STATE OF WASHINGTON  
DEPARTMENT OF ECOLOGY

February 29, 2008

Thank you for the opportunity to provide additional comments on the optional determination of non-significance process for the cluster plat of approximately 21.03 acres into 14 lots, proposed by Todd and Terry Geiger [P-07-53], also known as Dakota Heights LLC. We have the following additional comments to Ecology's previous letter dated February 12, 2008:

DAKOTA HEIGHTS
PERFORMANCE BASED CLUSTER PLAT
KITITAS COUNTY, WASHINGTON

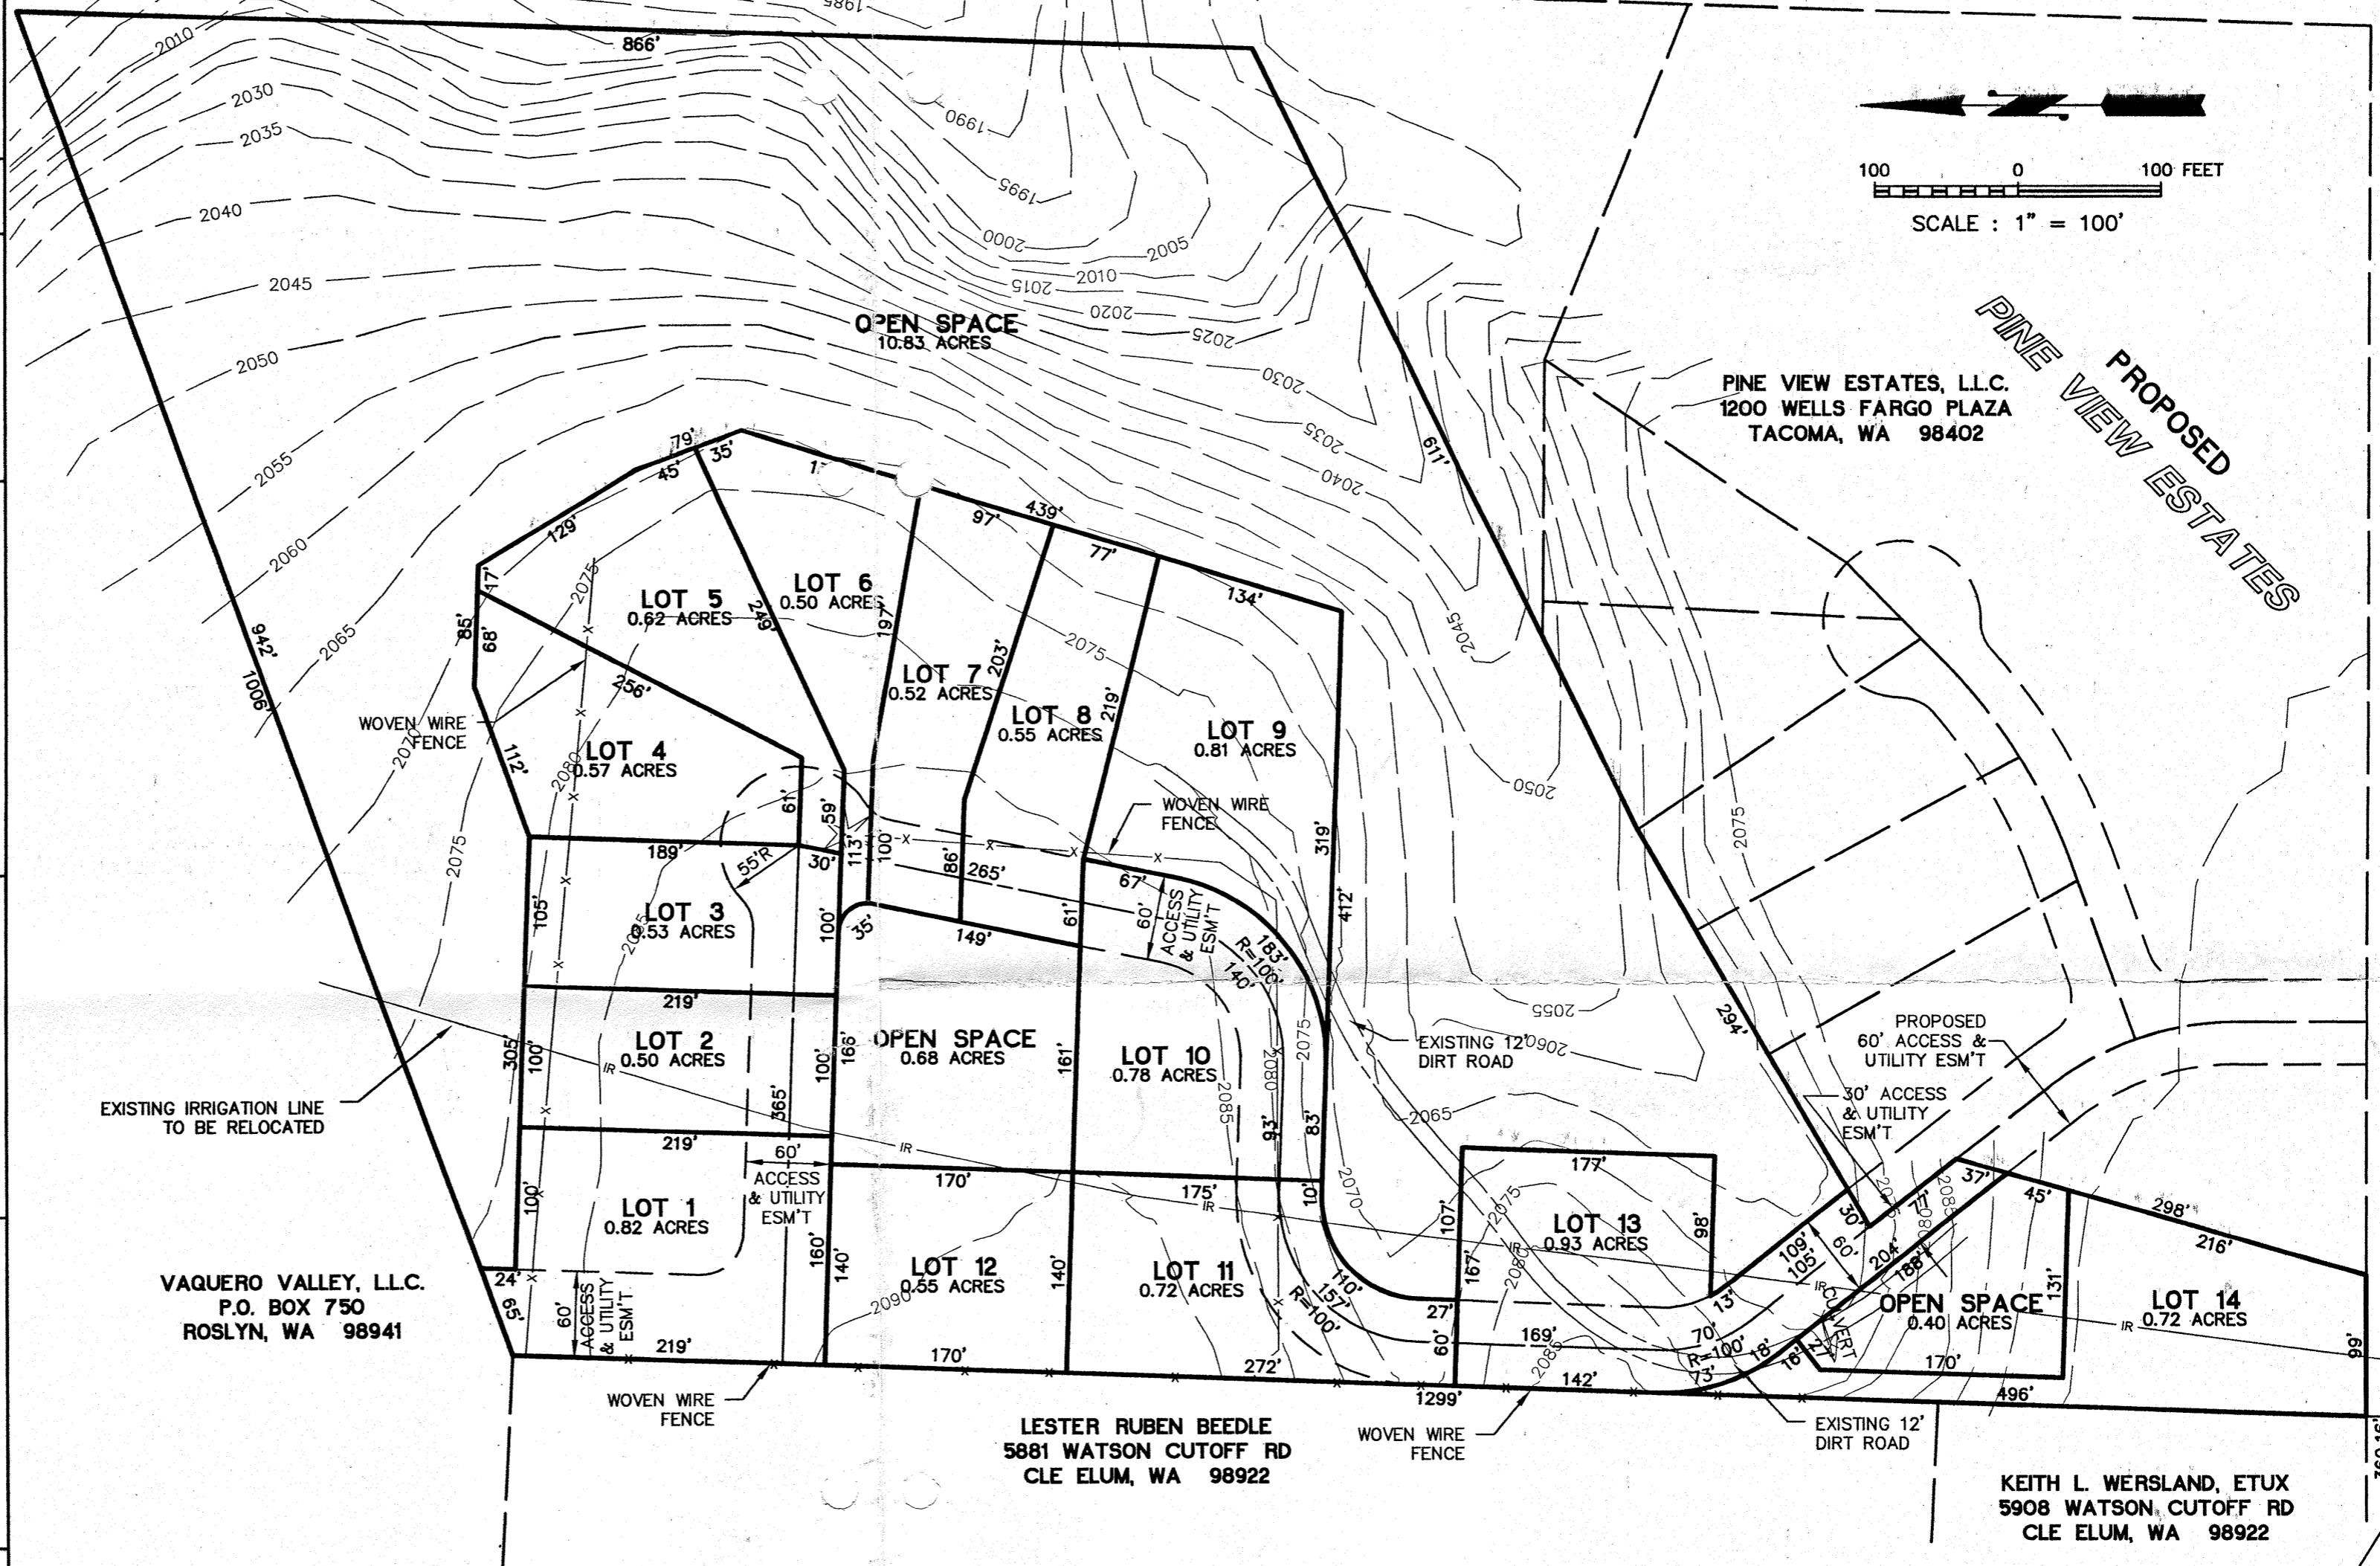
According to the map attached to the current proposal, File No. P-07-53, roads will be shared with adjacent parcel No. 1916060100008. This adjacent parcel, owned by Pine View Estates LLC, was one of the original 14-lot Performance Based Cluster Plat (File No. P-06-20). Since there are still common facilities, interconnected plans, and relatively contemporaneous development of the two parcels which derive from a common parcel recently created, it is our opinion that the Dakota Heights parcel no. 1916060100019 continues to part of a larger a larger project. In other words, the change in ownership has not altered its status as part of the proposed group use.

In summary, Ecology considers at a minimum these two projects (Pine View Estates and Dakota Heights) to be a single project and therefore subject to cumulative environmental review and a group domestic use under RCW 90.44.050. Because the combined total 28 lots between both projects would exceed water use of 5,000 gallons per day under the groundwater exemption (RCW 90.44.050), these projects require a water right.
